FIVE ESTUARIES OFFSHORE WIND FARM

**Appendix B7 to Natural England's Deadline 7 Submission  
Natural England's Marine Processes Advice on the Applicant's Deadline 5 and 6  
Documents**

Planning Inspectorate Reference EN010115

03 March 2025

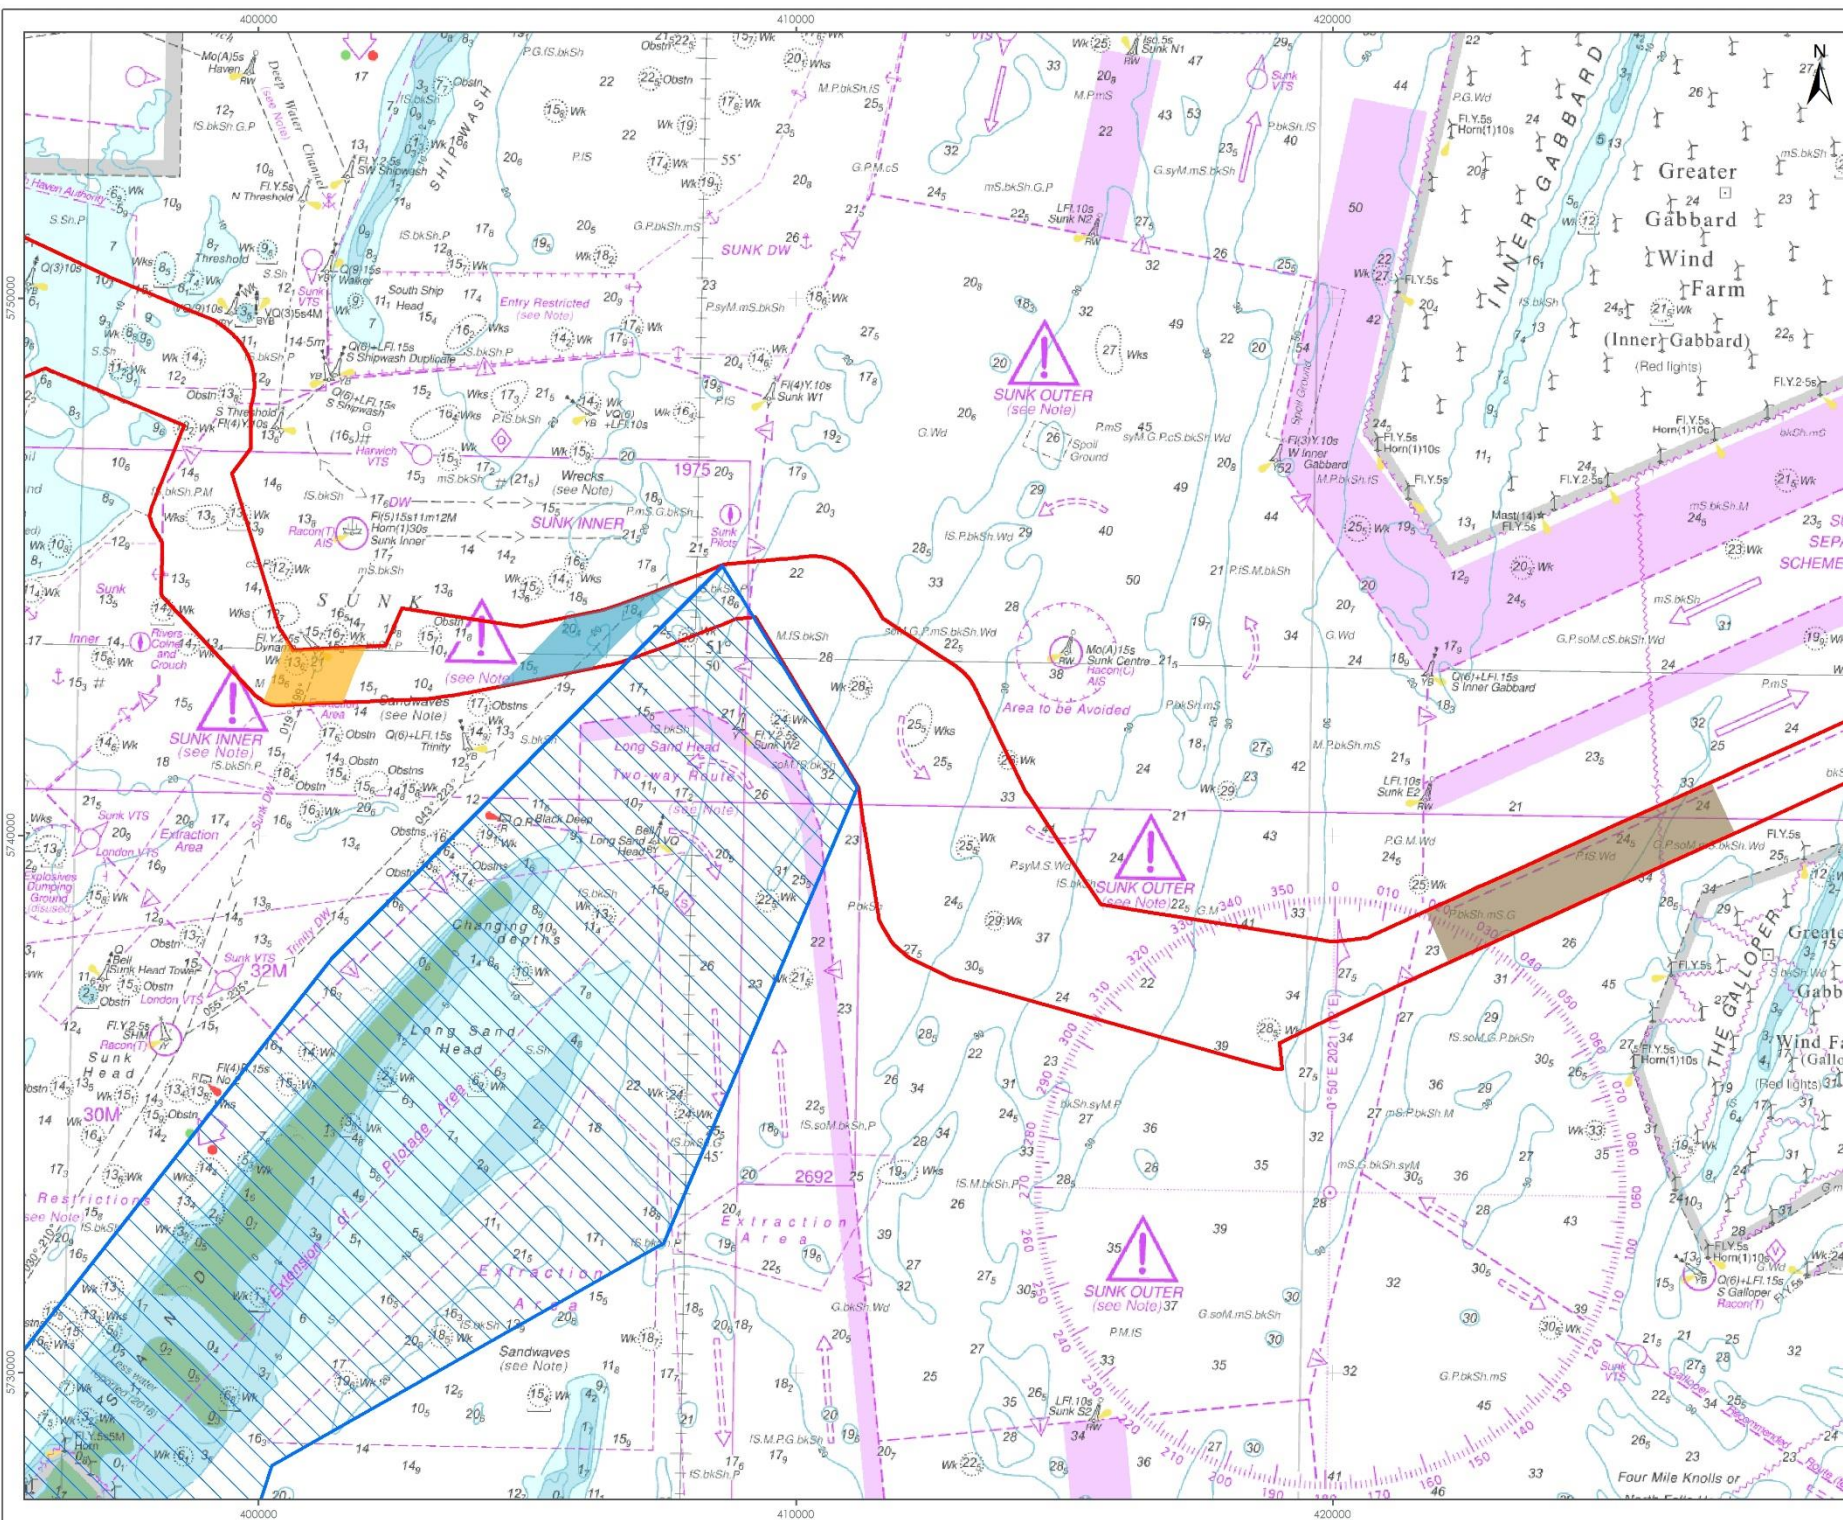
Please see our previous advice in relation to there being 3 disposal sites rather than the 2 included within 9.8 Dredge disposal site characterisation report.
